Further to my email of the 22nd November 2019 which provided an initial response to some of your comments raised in your 21st November 2019 consultation response regarding Land East of Shripney Road. By way of summary that email provided:

We have been provided with your consultation response dated 21<sup>st</sup> November 2019 in respect of the above. This is attached for ease of reference.

You will note that the Designer's Response has resulted in modification to the site access junction, i.e. widening the bellmouth and increase in the southern kerb radius. Please find this shown on drawing HTp/1845/05/A attached. This plan also shows the visibility splays, please let us know if this is unclear. We

DATE:	DRAWN BY:	CHECKED:
21/10/19	BL	DT

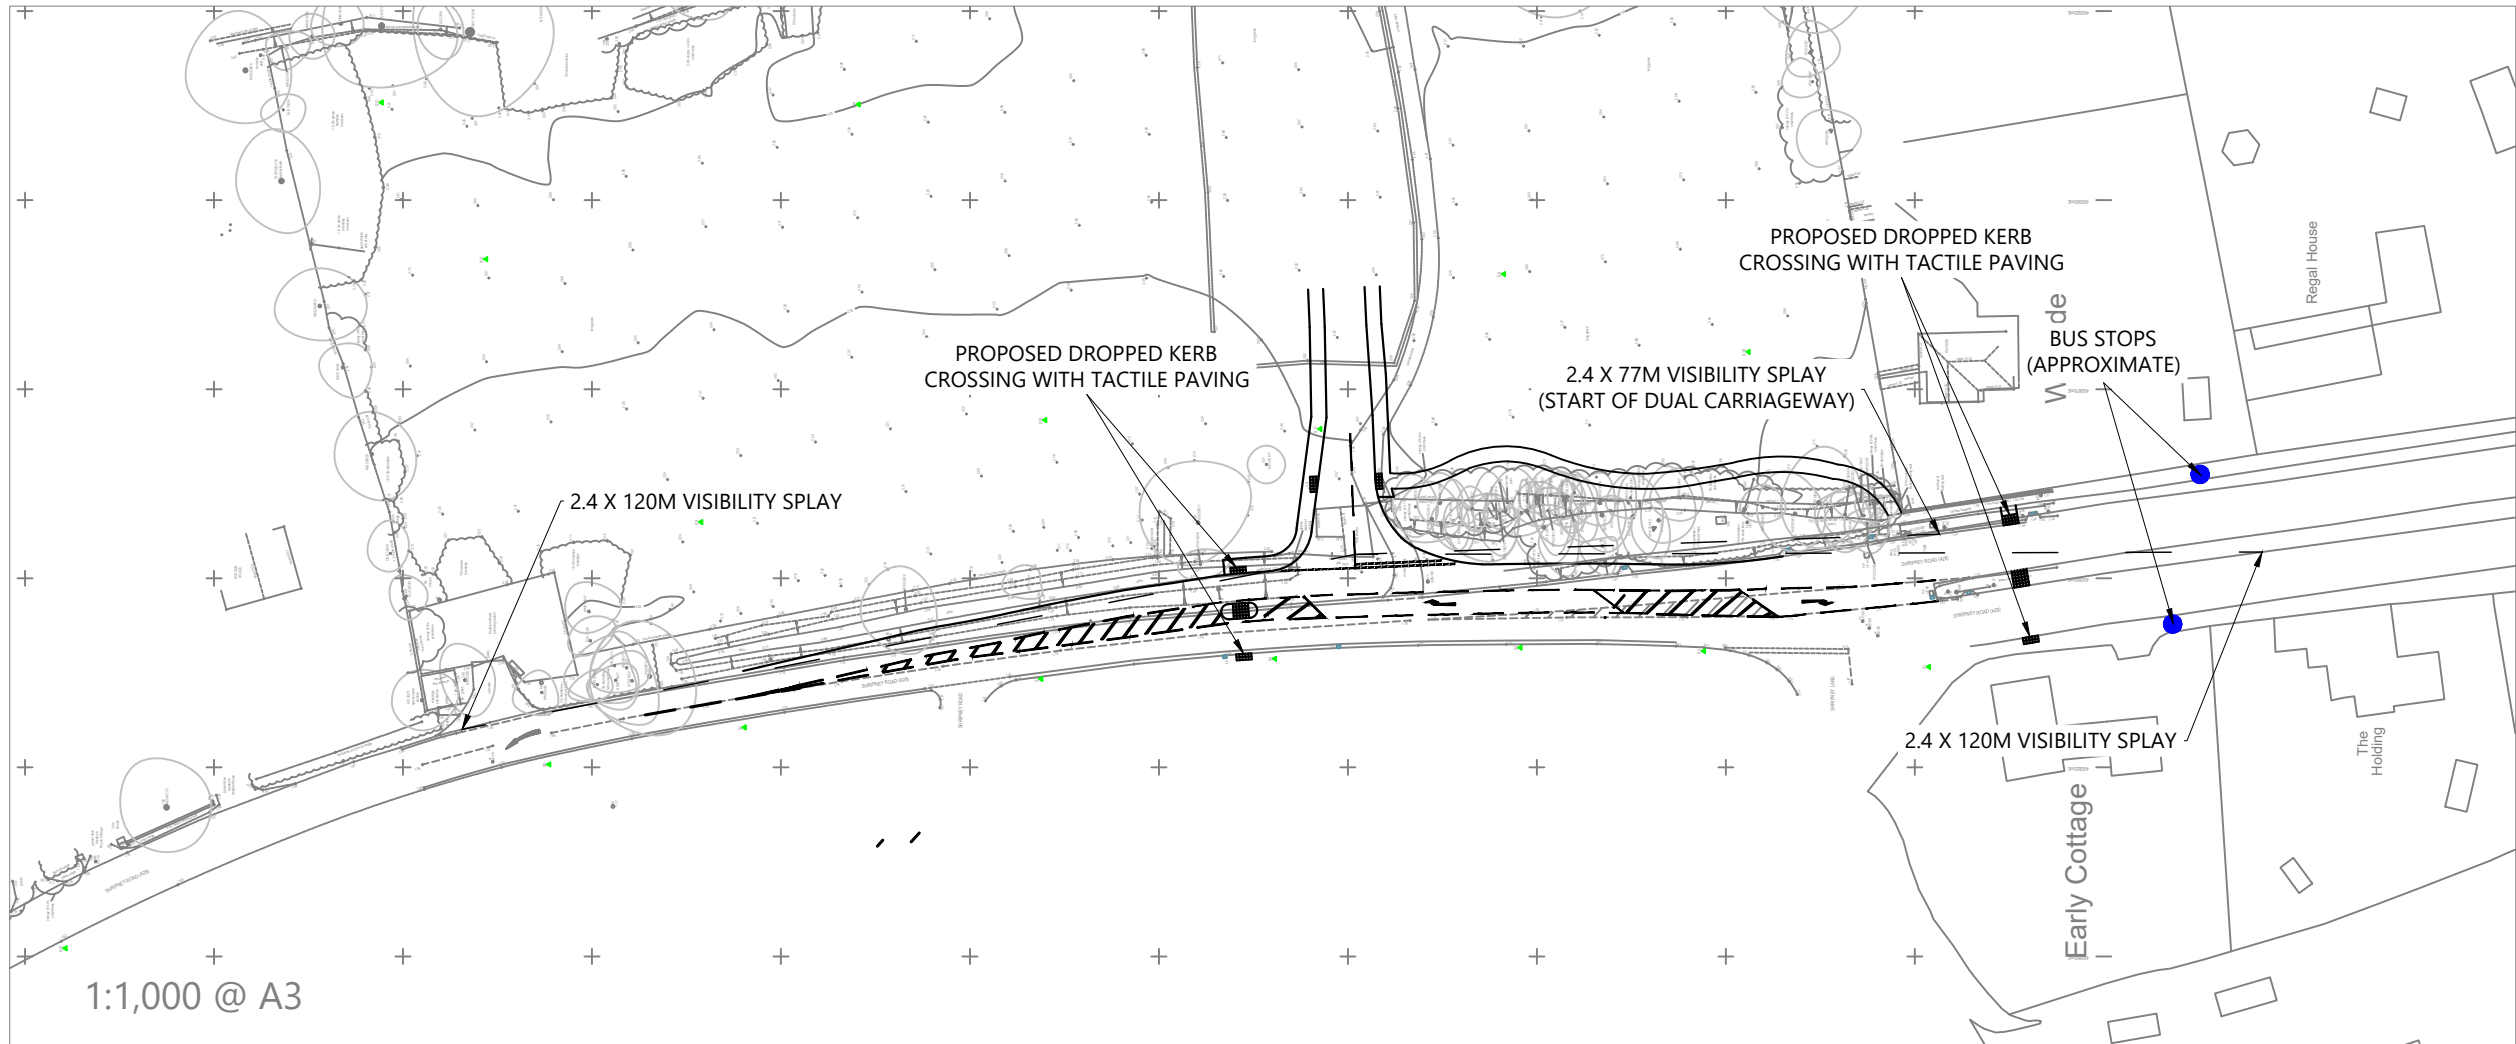
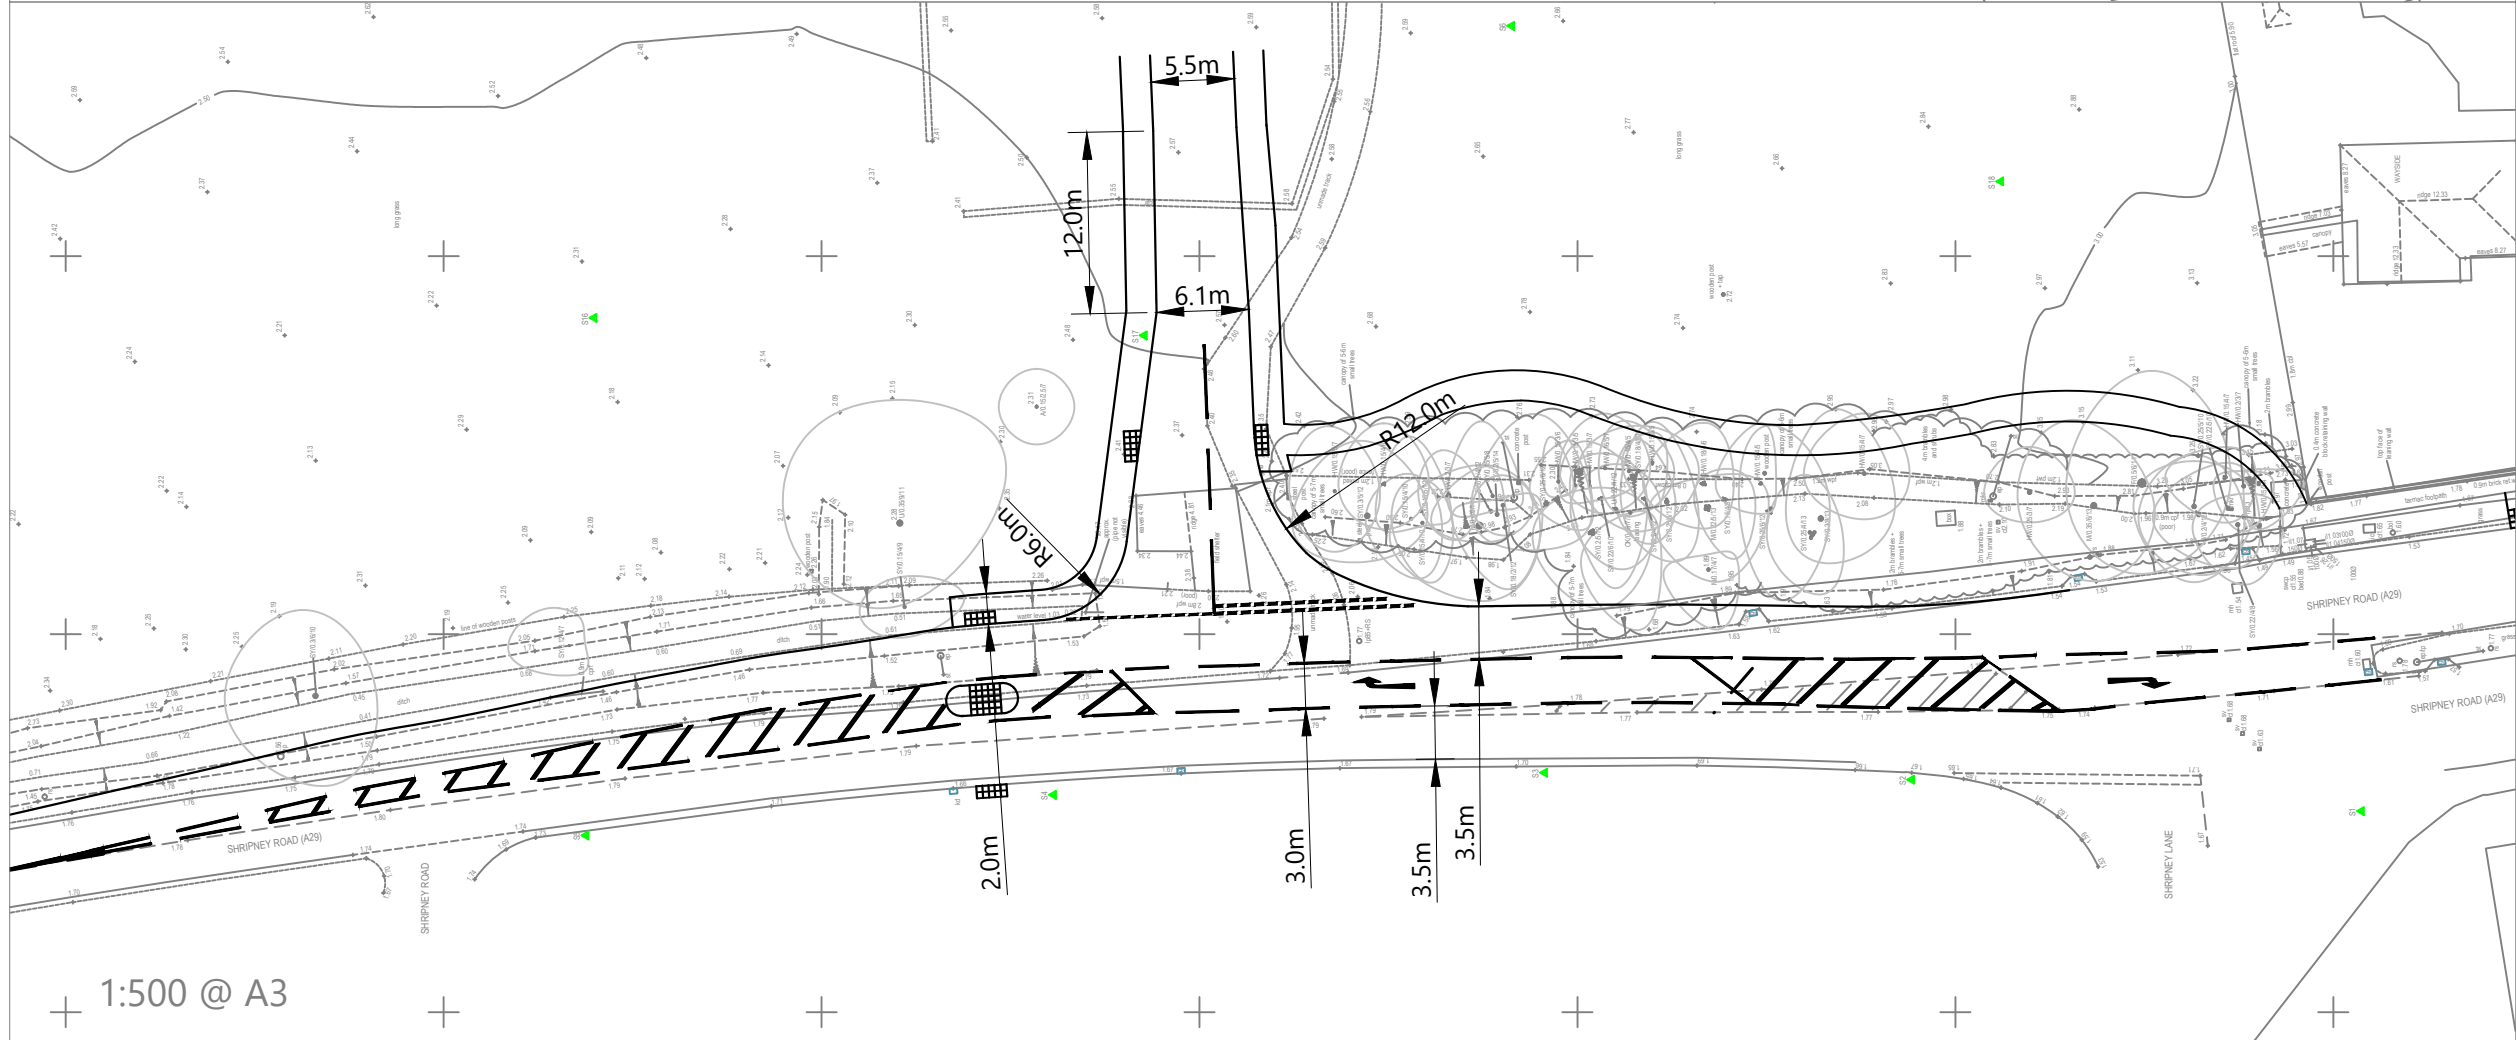
2. Your concerns regarding pedestrian desire lines and the non-continuous footway along the eastern side of Shripney Road to the south are noted. We have now added a dropped kerb pedestrian crossing of the A29 just after the start of the dual carriageway section as suggested. This is shown on drawing HTP/1845/05/B attached.

TITLE:		
REFUSE SWEEP PATH ANALYSIS - REVISED SITE ACCESS ARRANGEMENT		
DATE:	DRAWN BY:	CHECKED:
21/10/19	FB	DT

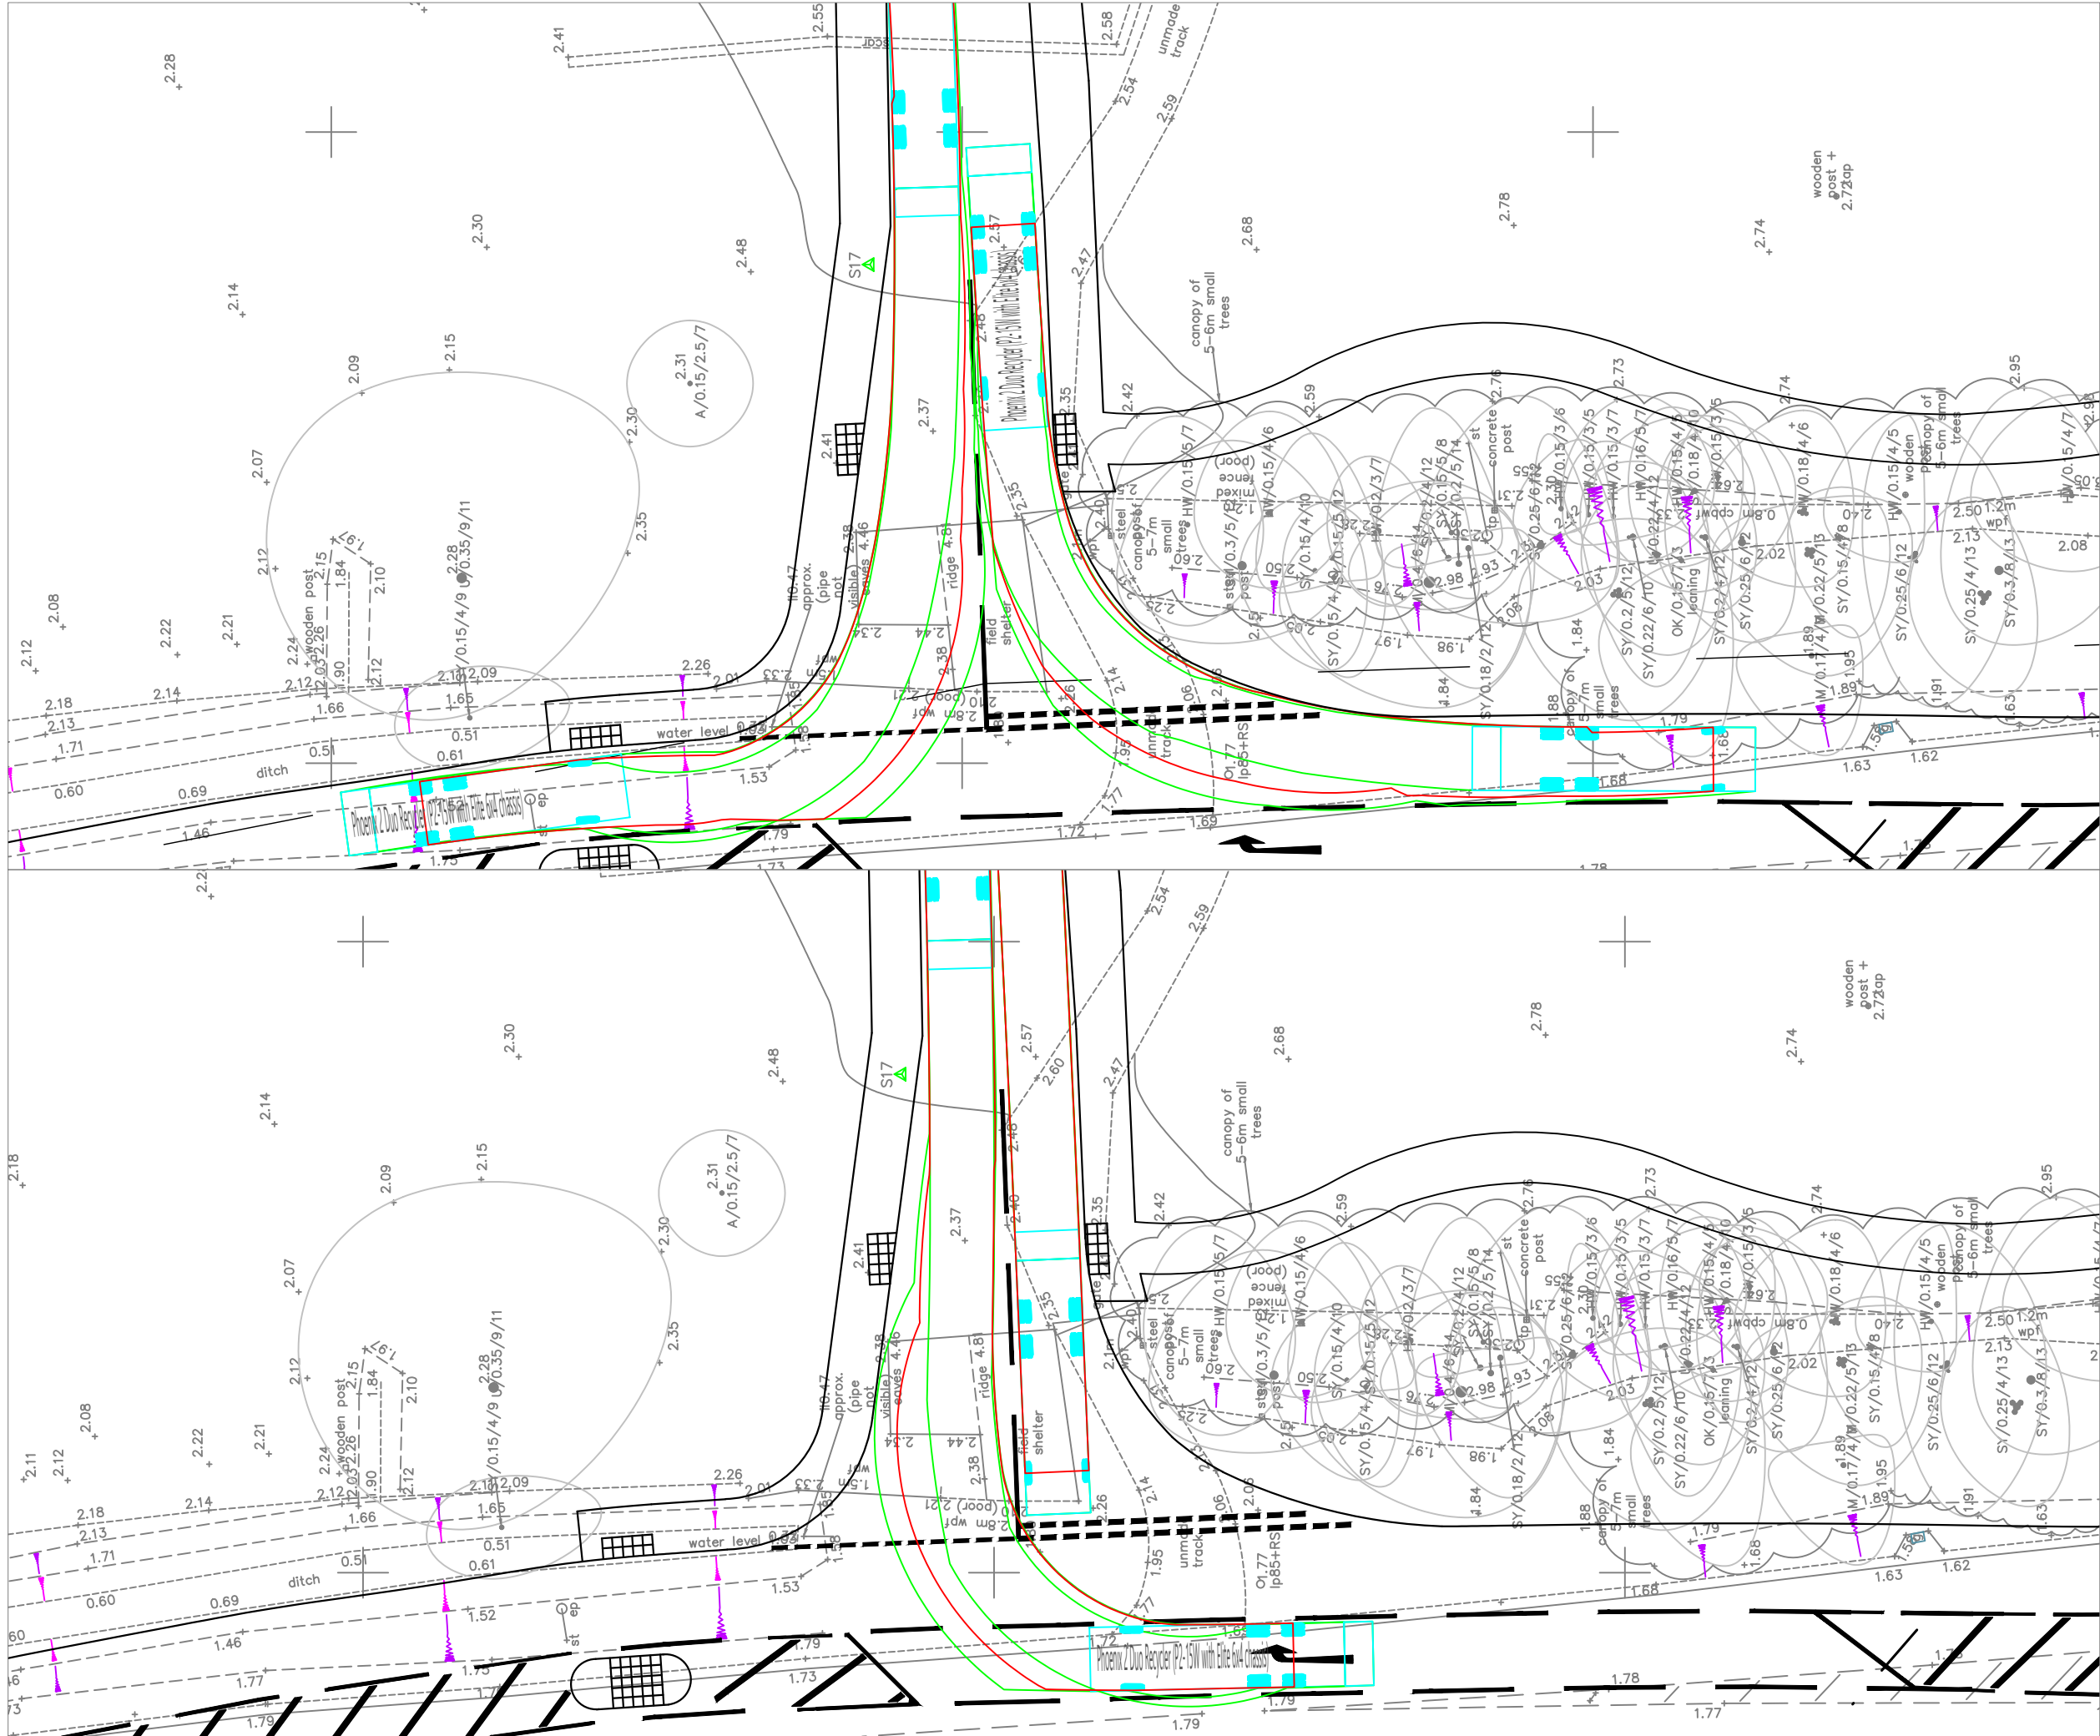
7. You expressed a preference to widening the junction radii to 9.0 metres. You will note that as a result of the RSA, the bellmouth was widened and the southern radius increased to 12.0 metres for swept path analysis of large vehicles. Do you still think it is necessary to increase the northern radius to 9.0 metres?

also attach Swept Path Analysis plan HTP/1845/TR04/A of a refuse collection vehicle using this modified site access. Again, please let us know if this appears unclear.
